**Re: SP23-006 – Linscott-Kirk Short Plat – Technical Review 1**  
9803 48<sup>th</sup> Dr NE – APN(s): 00538500001200

After preliminary review of the above referenced proposal, the Planning Division has the following comment(s):

PRELIMINARY SHORT PLAT MAP  
 FOR  
**LINSCOTT - KIRK SP**  
 IN THE SE 1/4 OF THE SE 1/4 OF SECTION 16, TWP.30 N., R.5 E., W.M.  
 CITY OF MARYSVILLE, SNOHOMISH COUNTY, WASHINGTON

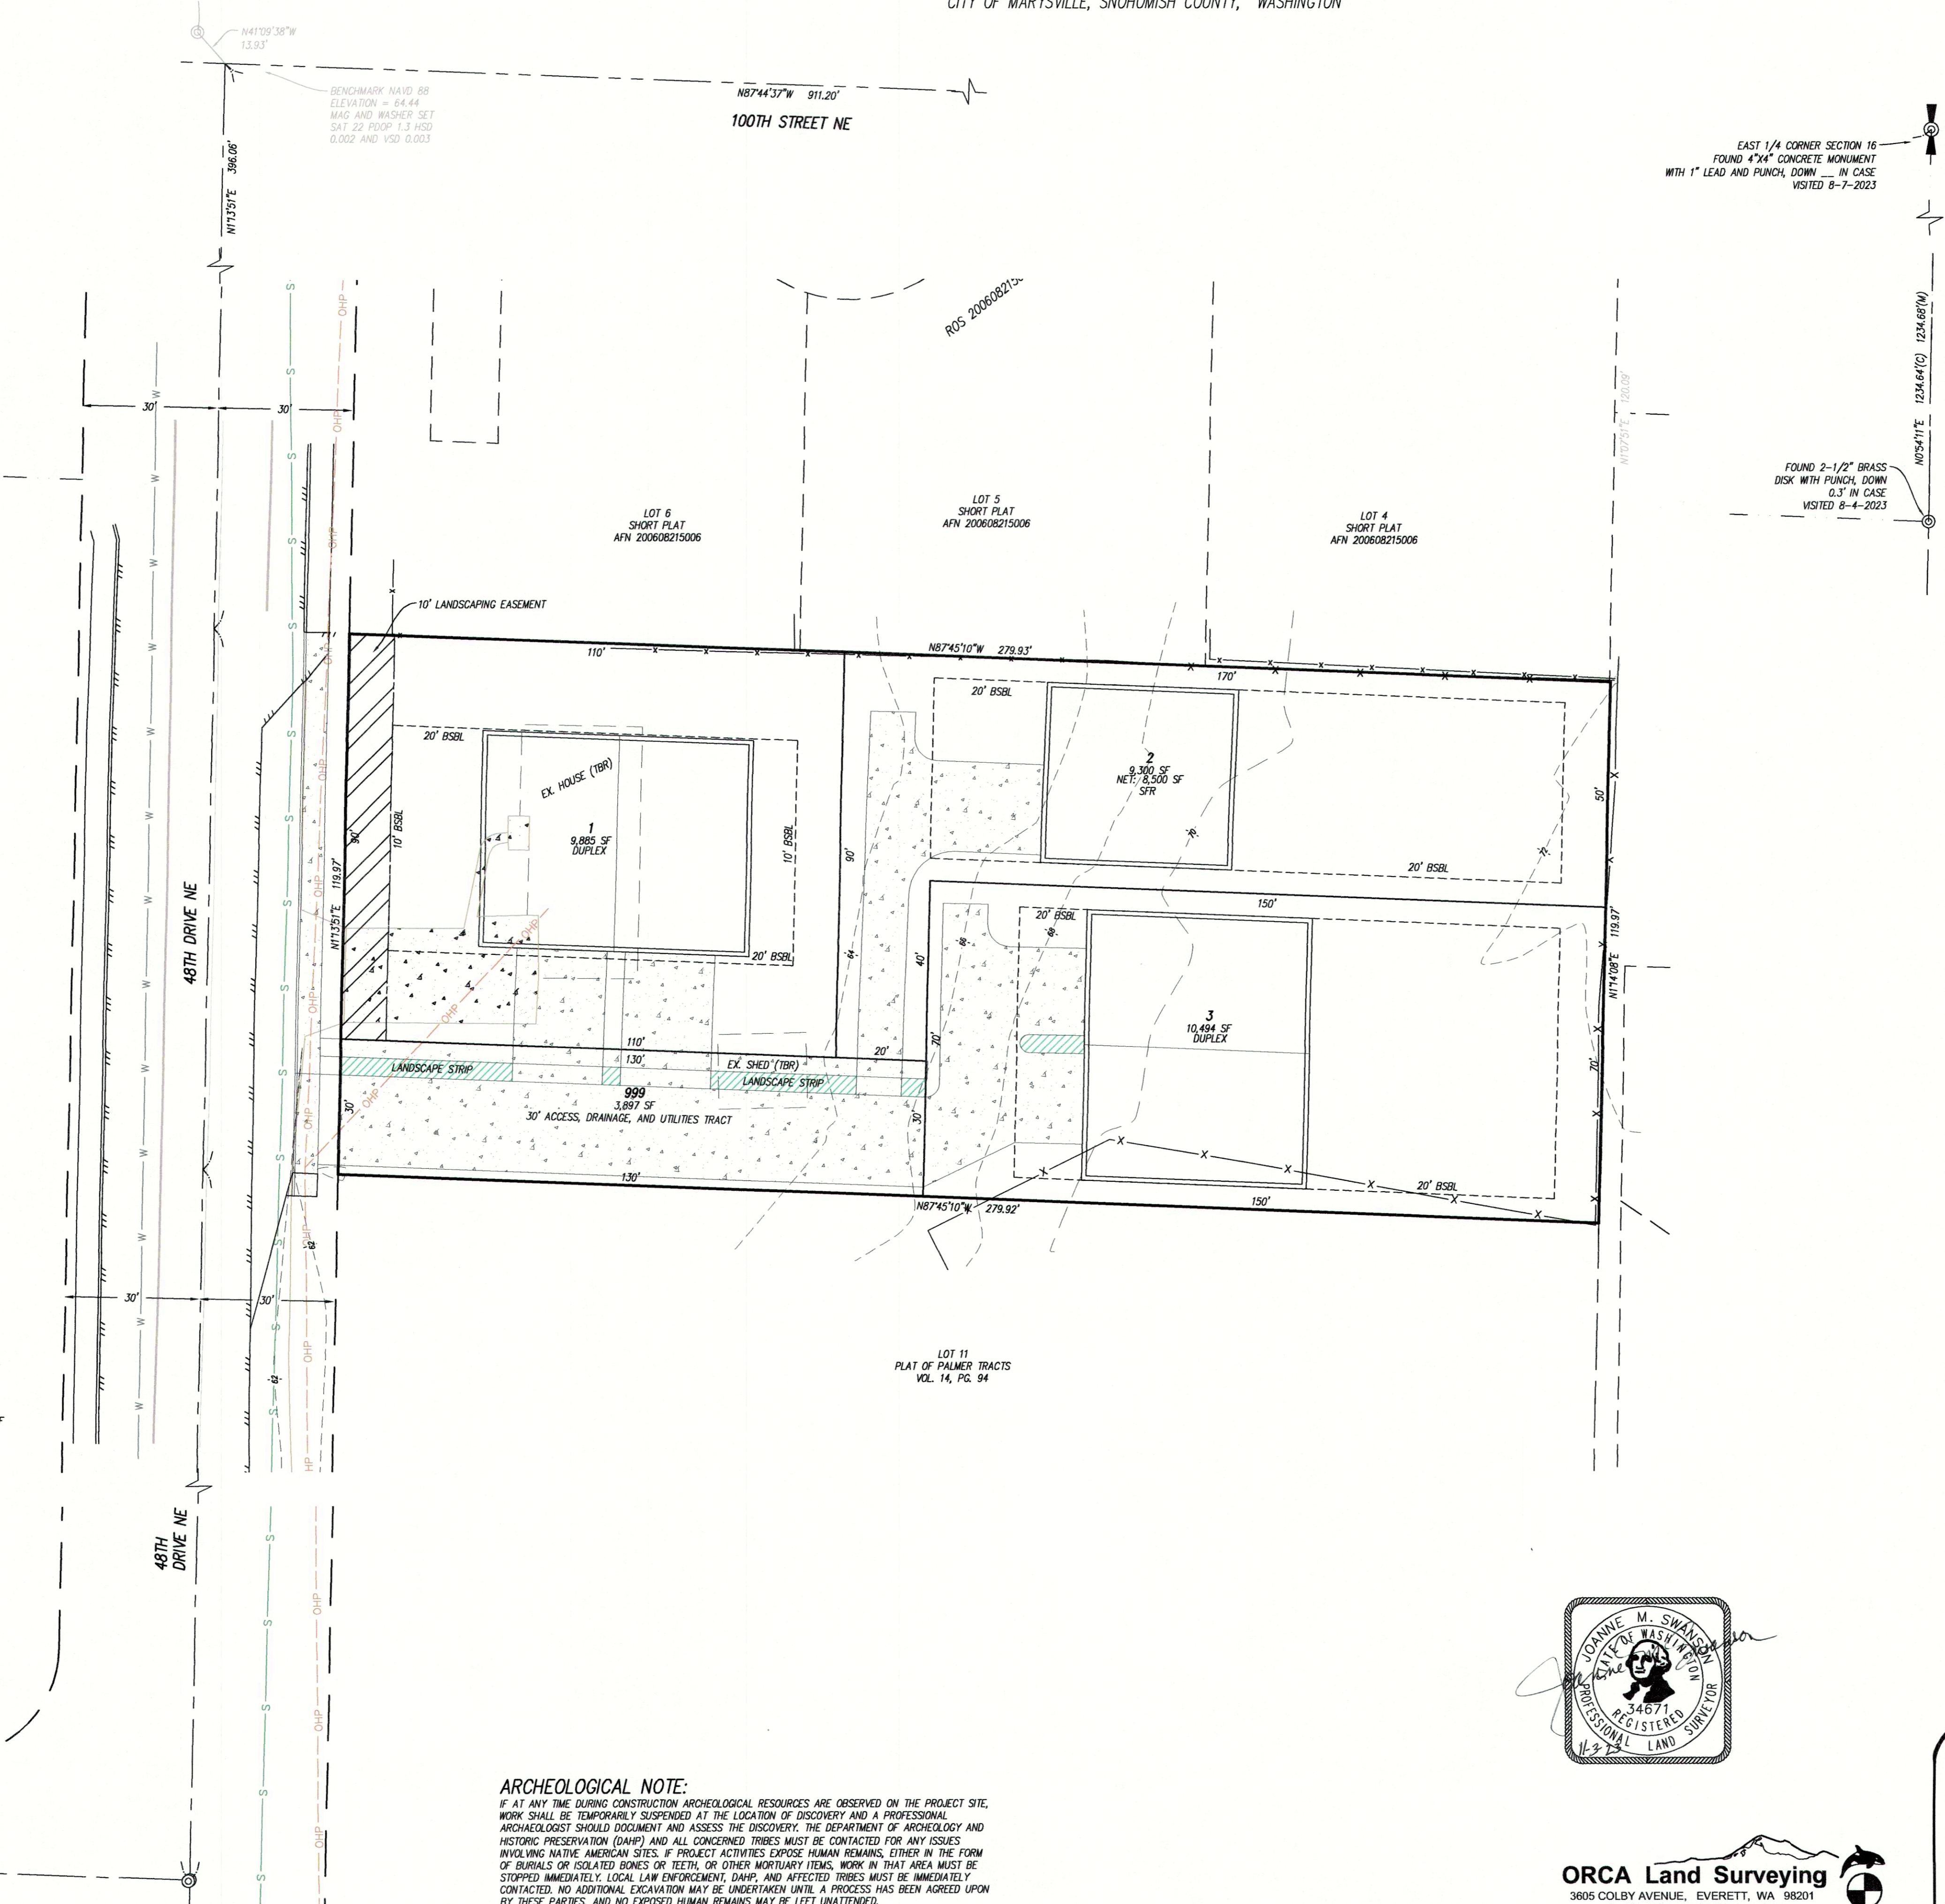
1. Include File Number SP23-006 on all future correspondence, in addition to all site, civil and landscape plans.
2. Per [MMC 22C.010.290\(2\)](#), sites shall be oriented to create an attractive street edge and are to have primary entrances facing the street. Additionally, street facing residences would be consistent with the character of the neighborhood. As proposed, Lot 1 would not meet the intent of this section.

Staff does note that the comments from the pre-application mentioned that if units along 48<sup>th</sup> Dr NE are not oriented towards the street, then a 10 ft. landscape easement would be allowed. However, this is not an allowable or desired deviation to the above code section. Revise site plan to remove the proposed landscape easement and orient the lots to have the primary entrances facing 48<sup>th</sup> Dr NE with garage access in the rear.

**Staff proposes the following configuration:**
